RESPONSE TO
City of Albuquerque
Plan Check Division

Response For: Permit No. BP-2023-02312 8737 West Central Ave.

For letter of comments dated Dec. 26, 2023

**Site Development Plan**  
 (8739) 8th Street at West Central Avenue

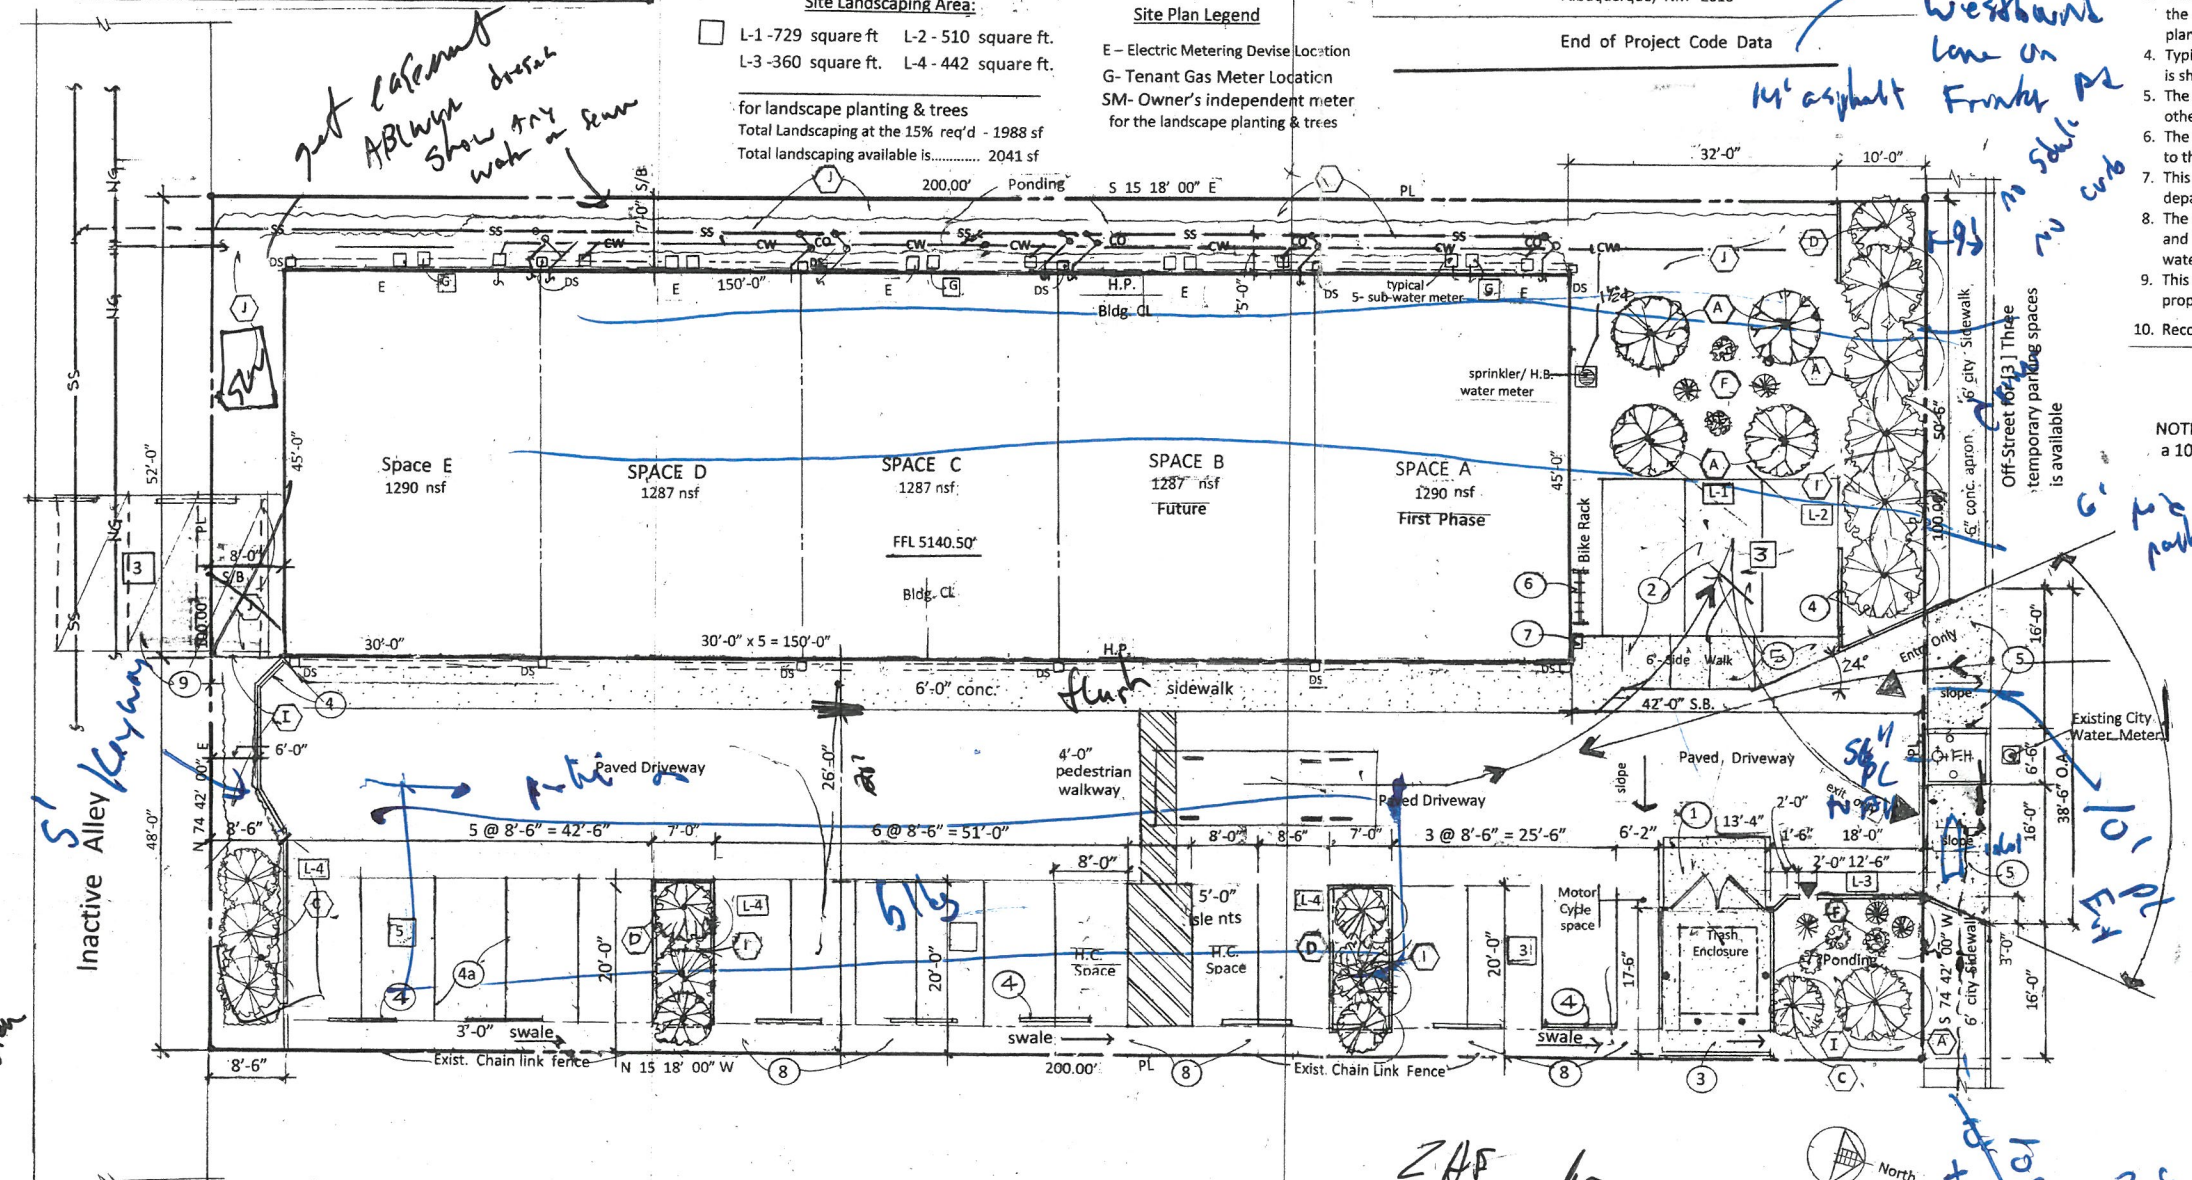
Item No. 2 – The number of parking spaces has been discussed over and over again with various reviewer, mostly with Mrs. Trujillo and it was agreed that we were providing as many spaces as the site permitted. All that documentation is on the latest plan dated September 29, 2023. The parking count is based on the use for Light Retail purpose. I refer you to the dated TCL Plan, nothing more can be done. **Not able to provide more spaces.**

Item No. 5 -- Site access is as shown on the latest TCL and the revised Site Plan dated on Sept. 29, 2023, although we were not give any drawings or information regarding the swales and the property access paved driveways for entry and exiting to the site are shown within the front limits as shown on all the plans, refer to TCL plan dated Sept. 29, 2023. There are no access design details to our knowledge.

Item No. 6 -- This comment regarding one-way access does not apply here, what is shown on the TCL plan is what can be expected due to the City of Albuquerque's major changes to access from the Frontage Road, we had to accept what they did, including the placement of the fire hydrant, which ended up right in the middle of our proposed entrance driveway with original Site Plan, so we wish for the latest plans to be accepted based on the facts.

Item No. 8 – Refer to TCL plan for the dimensioned sizes of all regular parking spaces and the spaces motorcycle area of at 17'-0" x 6'-2" [2- or more can be parked in the space

Item No. 9 -- Again we refer you to the TCL plan which clearly show the 8 ft. wide x 18'-0" access isle between the two assigned ANSI parking spaces as adequate for # of spaces.

Item No. 18 -- The keyway at the south end of the last parking spaces has been altered and the showing of curbing has been removed, since that space is now devoted to access to the last 3- employee parking spaces in the un-improved alley space, the drive space for the spaces is recommended to be compacted gravel. The legend symbol "J" no longer applies and the KN # 4 has been removed as a reference. The keyway is now very clear and open, refer to the revised attached page of that area.

Item No. 19 -- The pedestrian pathway is currently shown as 4'-0" wide. it can be 6'-0" . but what difference does it make, most people will not really use it, they will walk from parking in an direction they wish towards the building. The contractor will be advised to We are herein agreeing that the pedestrian pathway be 6'-0" wide, no details needed,
Item No. 20 -- Has been responded to in Item No. 19 above.

Item No. 26 -- The clear sight triangle has been addressed on the final C-1 and other plans and it is the best that can be demonstrated, considering the disadvantaged position that the city has placed on the property owner with the placement of the F.H. in the middle. None of the suggested landscaping, mainly trees, interfere with the sight triangle, you should refer yourself to the C-1 for clarity in the matter.
